Objection 2 from

Date: 09.05.2024

[with reference to application documents: ES Volume 1 Chapter 14 Flood Risk and Drainage by Mott MacDonald, and the ES Volume 3 Appendix 14.1 Flood Risk Assessment and Drainage Strategy by Mott MacDonald, and Appendix H Site Walkover Technical Note by Mott MacDonald]

Potential Negative Hydrological implications of Proposed Stadium Development on the Triangle

Figure A.15: Existing ditch west of proposed OUFC site (ditch adjacent Frieze Way carriageway)

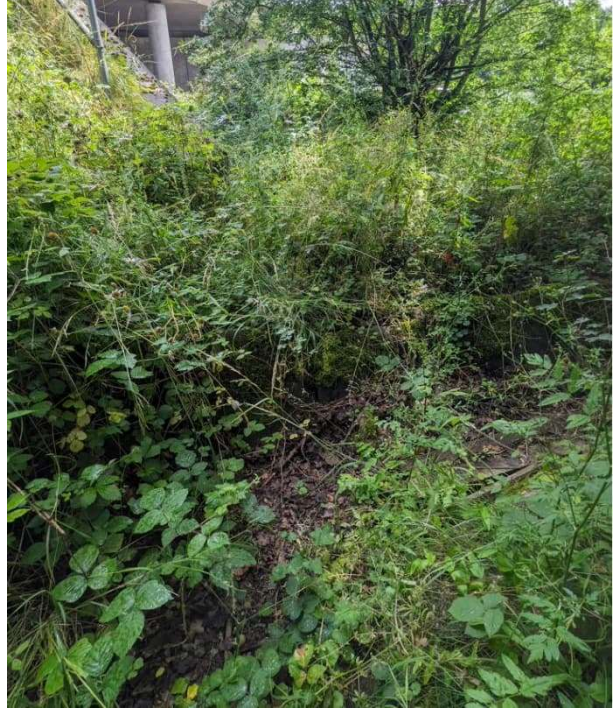
The ditches all around the site connect and drain from the lowest point on the west side ditch via an estimated 825mm diameter tube (Mott MacDonald measurement) – a concrete **culvert**, under Frieze Way to the deep ditch that runs westwards past Stratfield Brake West ancient wood section. This culvert pipe is said to be 85% blocked with silt (I agree, I have investigated and seen it so, but water still flowing out, photos below). Frieze Way opened between 1960 and 1963 and cut the original Stratfield Brake Ancient woodland into two halves. The culvert under Frieze way is approximately in the position of the original woodland ditch running along the original northern margin of the wood, before the road.

Water has been backing up in that western Frieze Way ditch going south to the culvert position because there is an access causeway to the Triangle field (maybe for agricultural machinery?) from Frieze way crossing that ditch. A drain pipe emerging from the causeway wall 30cm down shows no flow (no explanation for this) BUT I saw water bubbling up from deeper underneath the causeway so water is finding a way underneath, but flow not fast enough to lower ditch water level to north of causeway. See photos below.

This blockage & backing up (combined with extremely heavy rainfall) in that Frieze Way ditch has meant the lowest area of the Triangle site on the west side has not drained but been

Figure 8.1: Proposed Catchment Areas

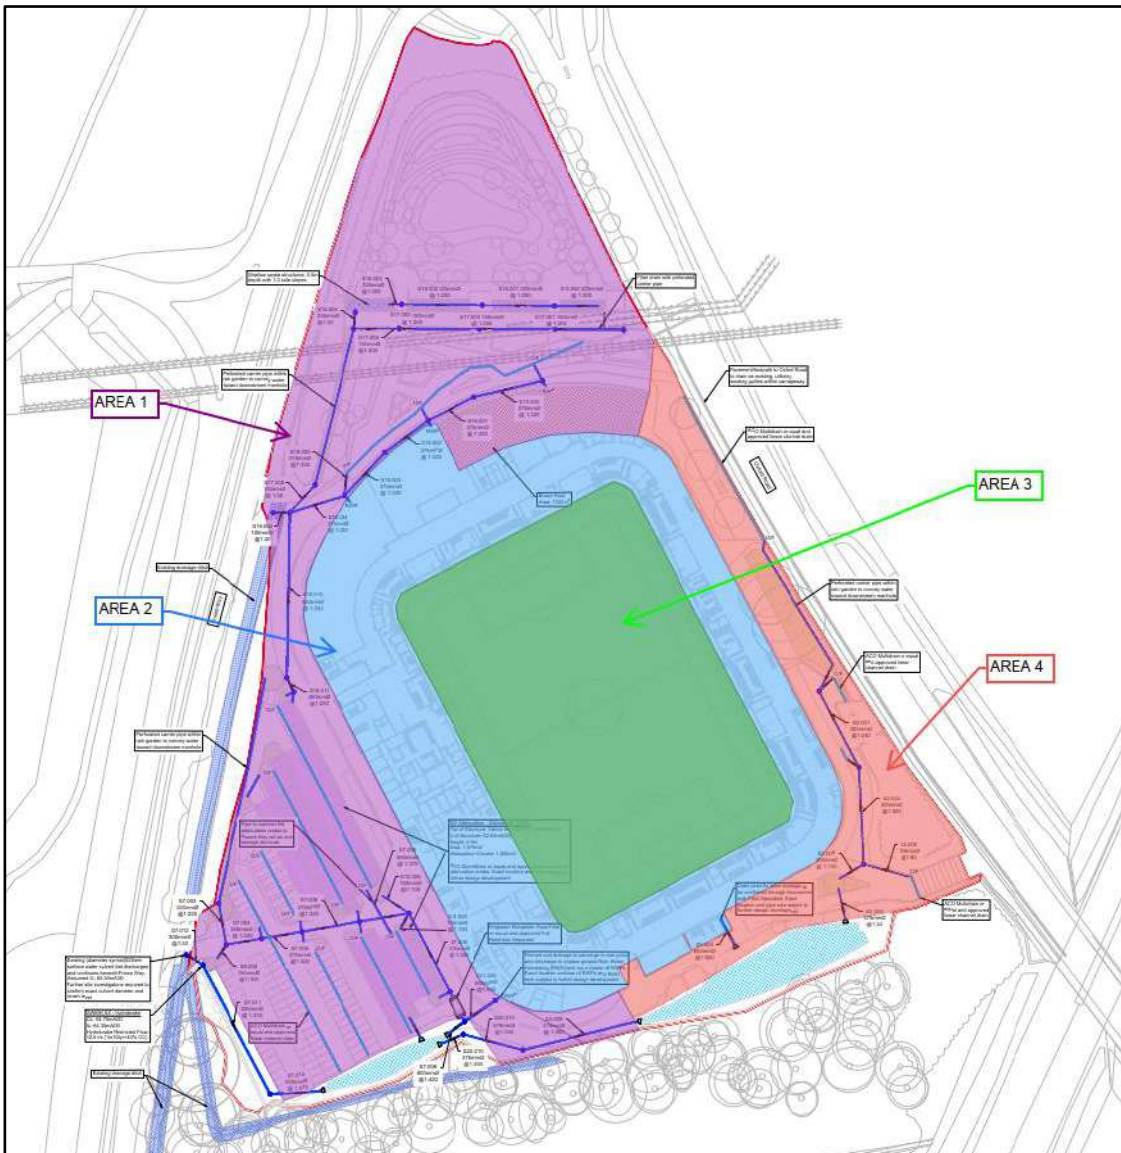
There is planned be massive amount of **attenuation pond** and **underground storage capacity** for run-off water - a storage volume of between 3164 to 4220 cubic metres of run-off water in total is quoted. This includes a total from all the planned geo-cellular crates under the car park and all the volume of attenuation ponds giving a total storage of **3,715 m³** of rain water to be stored on site and evaporated or released slowly. **All the SuDS structures need regular desilting maintenance for optimal functioning or storage will decline, I can’t find any details of this planned essential maintenance.**

All the run-off from the site will go to the western ditch along Frieze Way and have to have flow rate impeded by **hydrobrakes** to leave the site at the necessary ‘**greenfield rate**’ of **11.6 litres per second** so as not to increase flood risk elsewhere (for the 1 in 100yrs plus 40% for climate change storm event). All the roof water from the Stadium will go to one of the attenuation ponds at the south, but **might be stored in tanks first and no design plans yet**

The open water SuDS '**attenuation ponds**' at the south side, next to Stratfield Brake East Ancient Woodland will perhaps be separate to the south drainage/boundary ditch there (? presumed, this is not discussed). They are stated to hold a total volume of **1769 cubic metres** and be **lined to prevent groundwater ingress. What will stop them receiving surface water overland flow from paving after a deluge rainstorm?** Flow from the attenuation ponds to the western ditch outflow position is stated to be controlled by a **hydrobrake** to a greenfield rate of **11.6 l/s** (or stated to be a revised rate to be agreed with Oxford County Council and Oxford City Councils- if this is the maximum safe amount, why would this be changed?).

'**Hydrobrakes**' are mechanisms within pipes which slow flow and can be clogged by detritus - things like **leaves and twigs** (which will be constantly falling into those ponds from the oak trees of the adjacent wood that over-hang this area). Even if they chop back those poor trees' branches, leaves will be constantly blowing in from the wood. Hydrobrakes will need checking and cleaning incredibly frequently to maintain function. It is a very bad idea to site attenuation ponds with hydrobrakes near or under trees for this reason. In accounting for any drainage failure problem, their stated plan is to **let the car park nearby flood:**
